**KIRKLEES COUNCIL
TOWN AND COUNTRY PLANNING ACT 1990
HIGHWAYS DEVELOPMENT MANAGEMENT**

PLANNING REF 2017/62/90620/W0/MW
CATEGORY Small Major

PROPOSAL DEMOLITION OF EXISTING BUILDINGS, CHANGE OF USE OF EXISTING BUILDING TO MIXED USES COMPRISING B1A, B1C, A3, C3 AND OUTLINE PERMISSION FOR ERECTION OF 75 DWELLINGS

LOCATION DOBROYD MILLS
HEPWORTH ROAD
NEW MILL
HOLMFIRTH
HD9 1AF

HYBRID APPLICATION PLAN

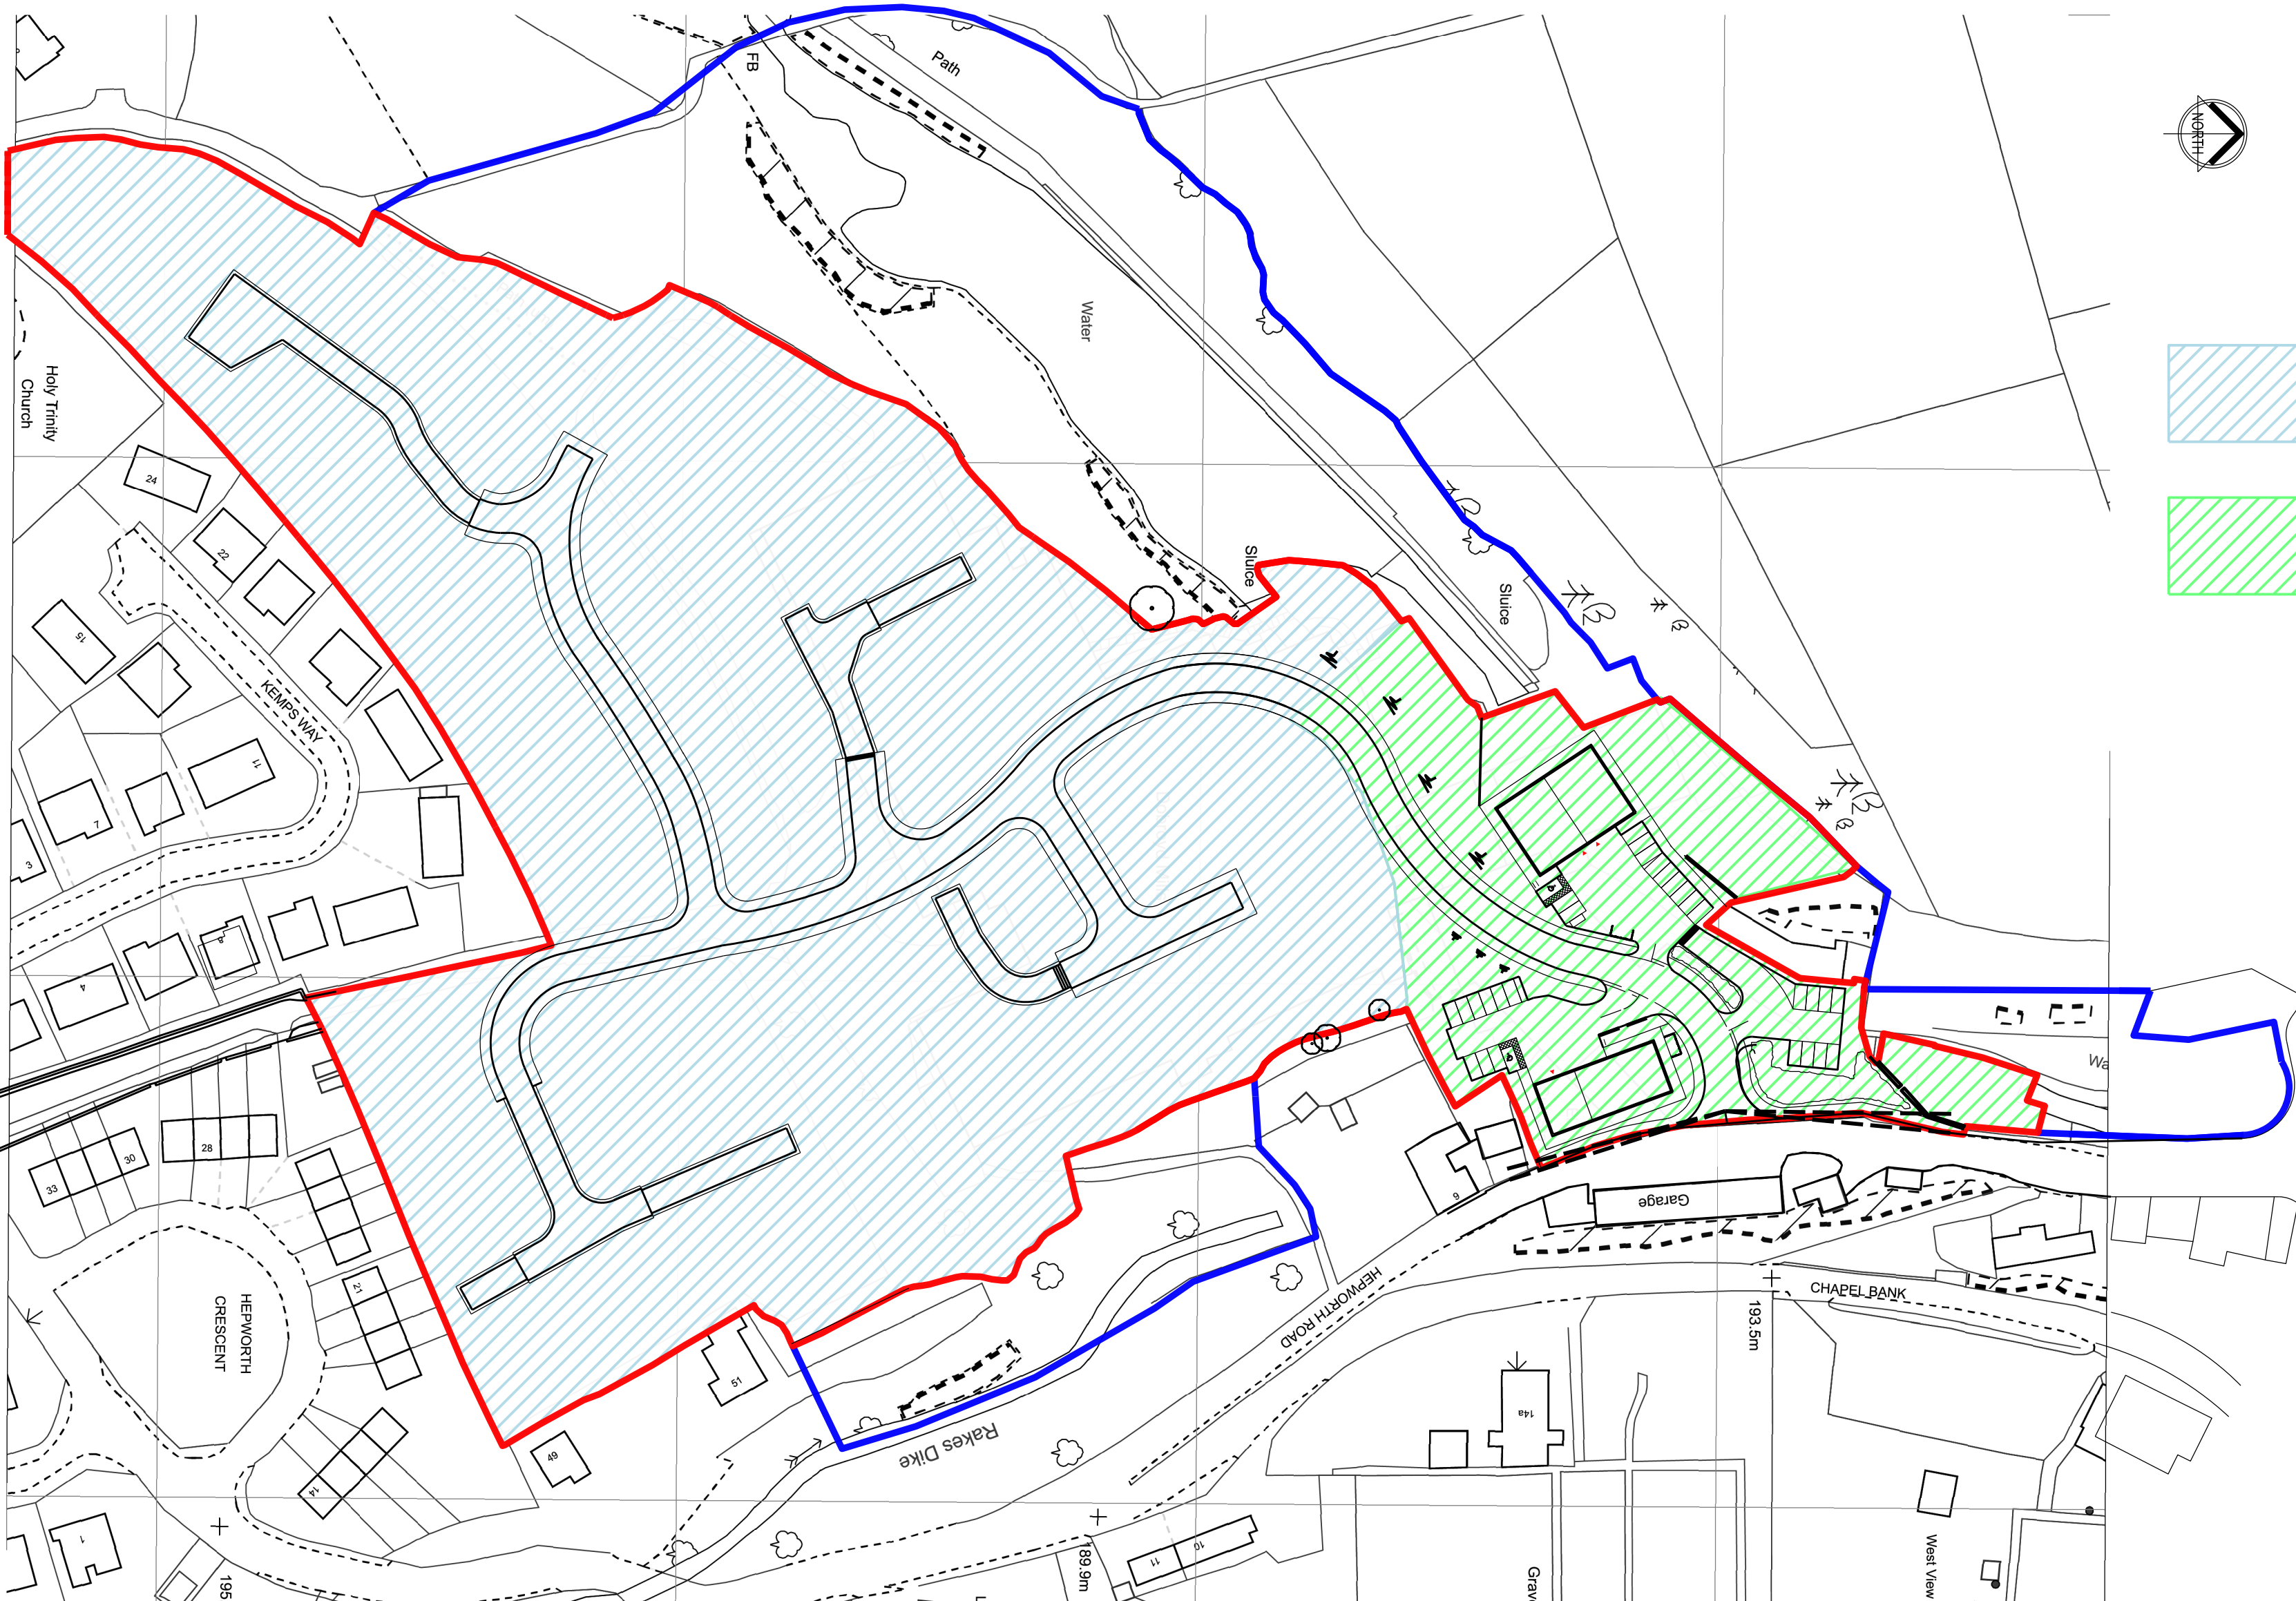
Notwithstanding the details shown on the approved plan, the development shall not commence until a scheme detailing the provision of a 2.0m wide footway to the Hepworth Road frontage of the development site, construction specification, surfacing, drainage and kerbing including the relocation of existing telegraph pole and street lighting column and associated highway works has been submitted and approved in writing by the Local Planning Authority. The development shall not be brought into use until the approved scheme has been implemented and thereafter retained throughout the lifetime of the development.

DRAWING No: 1604601c

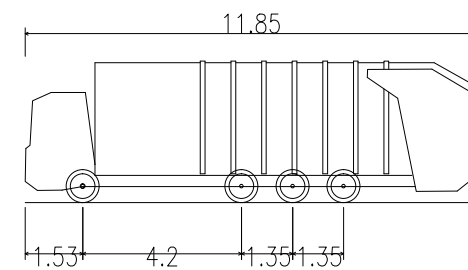
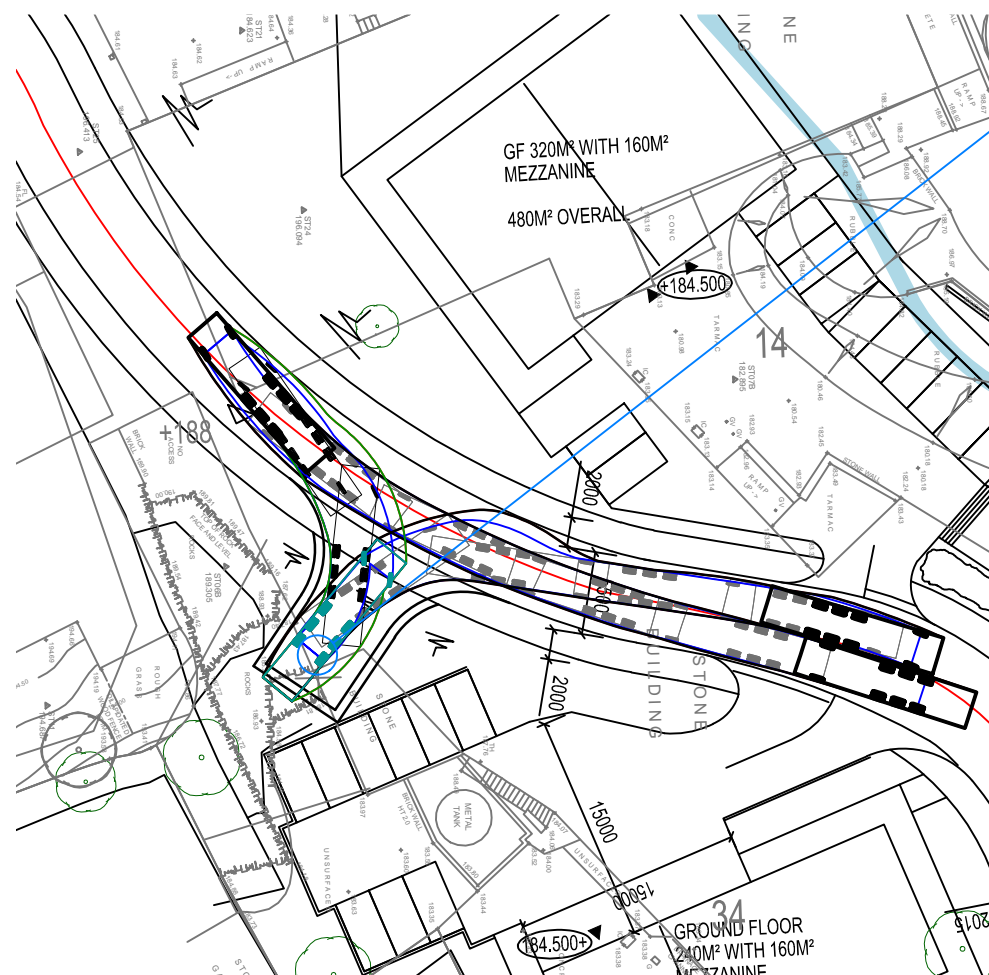
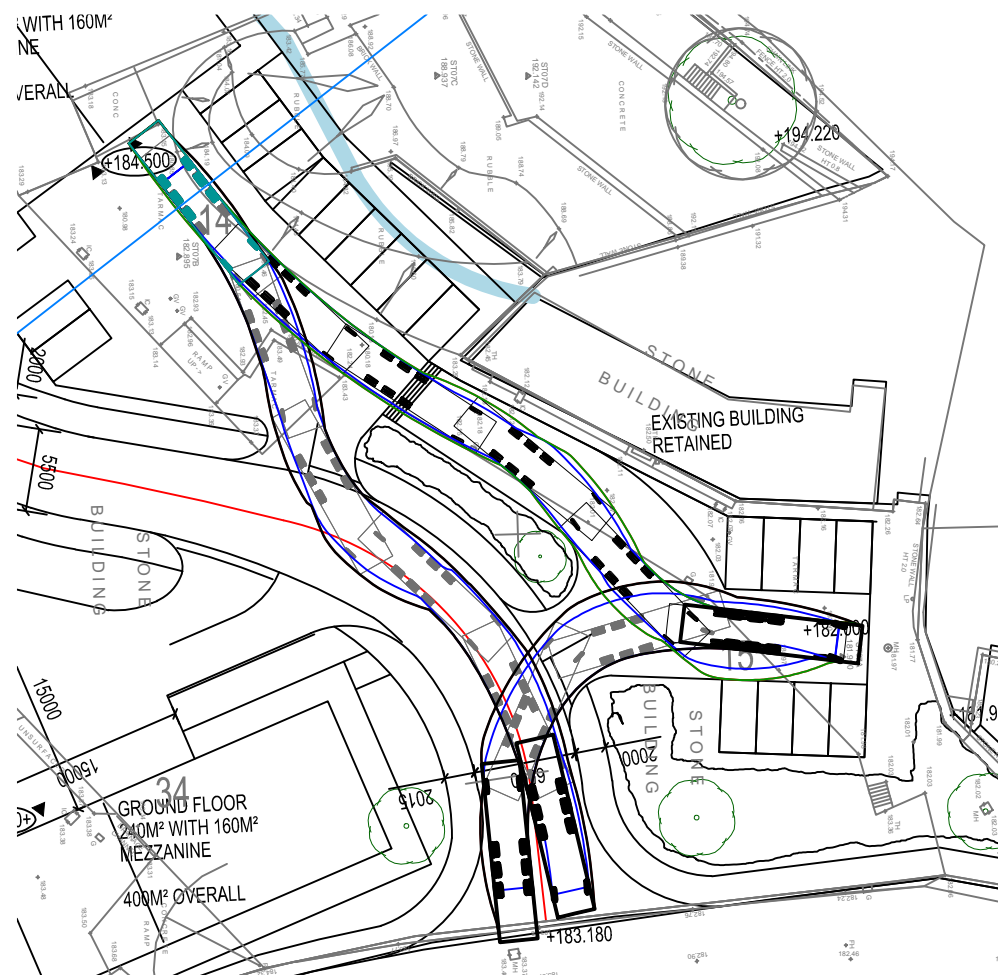
Before any building is occupied on the first phase of the development (employment site) temporary turning facilities shall be provided in accordance with the details shown on drawing no 11604601c attached to Via Solutions technical note 4. The turning facilities shall thereafter be made available for use at all times by vehicles and shall be kept free from obstruction to such use until such time that permanent turning facilities are provided within the second phase of the development (residential site).
